Job ID: 2011-12-2993-SF

**TO:** Dan LaBrie, Owner  
**FROM:** Jonathan Rioux, Code Enforcement Officer/ Plan Reviewer  
**DATE:** February 3, 2012  
**CC:** Jim Gray, Contractor  
**RE:** Job No: 2011-12-2993-SF. Located at 230 Holm Ave.

**RE:** Review Comments for Single Family Site Plan

**Project Name:** LaBrie Single Family

FOUNDATION PLAN
SCALE: 1/4" = 1'-0"

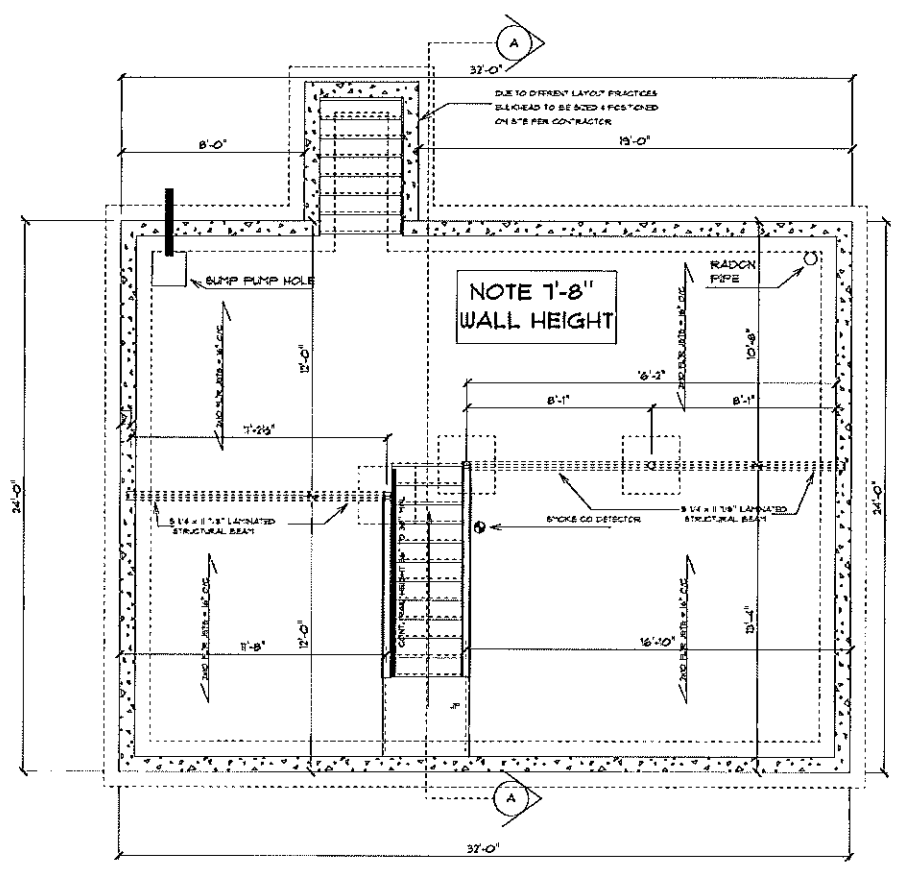
1. What is the max span between the triple (3) 2 x 8" Beam(s) and your ten (10) inch poured pier(s) for the porch/ deck?
2. What is the exterior wall sheathing? Plans indicate "per spec"? JGR.

The spacing is 7 feet between the piers center to center, and the sheathing is ½ inch Zip Wall with taped seams.

PORCH SECTION

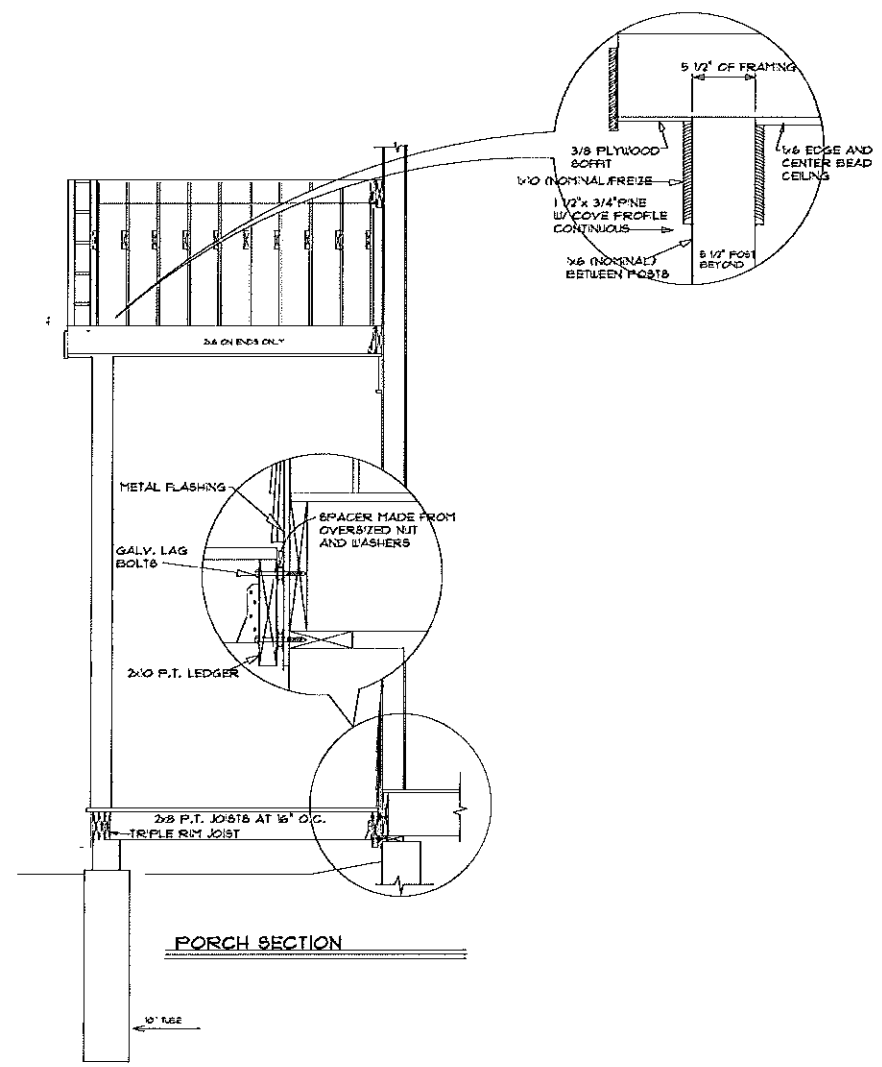
Cross-Section of the Deck/ Porch Construction (R502.2.1)

- Beam sizing and spans between each poured footing/ pier
- Floor Joist Sizes
- Ledger/ Beam Connection(s)
- Fall protection (36 inch minimal dependent on height from grade < 30 Inches)
- Stair Specs (rise, run, and graspable handrail)

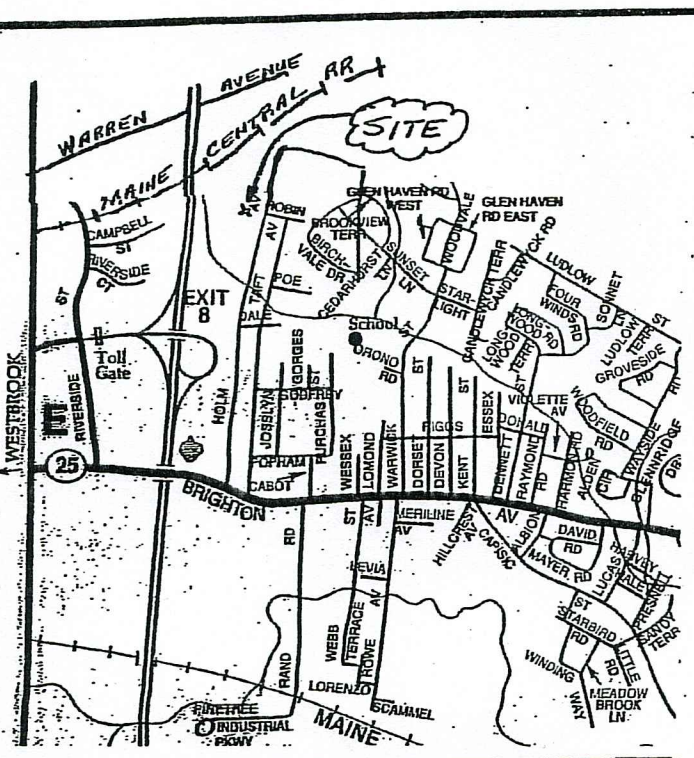
1. Please submit a revised survey to include the following information:
  - Please add the flood zone information to the survey, ie. which zone the property is in based on the FEMA Flood Insurance Rate Map.
  - Please include the approximate locations of structures on adjoining lots within 50 feet of the property lines.
  - Please add a revision block to the survey with the revision number and date.

- This lot has been split from an existing lot. Please submit a survey that shows the complete original lot with any existing structures, and the lot that is being split off.

- The site plan, building plans, and elevation plans don't match for consistency, please revise to address the following comments.
  - the bulkhead is not shown on the site plan

- the deck is not shown on the elevations
  - deck not shown on the building plans
- The bulkhead on the elevations is located 16.5' in from the back right corner, but on the building plan the bulkhead is located 10.5' in from the back right corner, right where the deck is shown on the site plan. Please revise so that all plans are consistent

- Please show two parking spaces (each one 9' x 18') that are 5' or more from the side property line for the first 50' from the front. Each parking space shown is 8' wide, and one space is only 2' from the side property line.
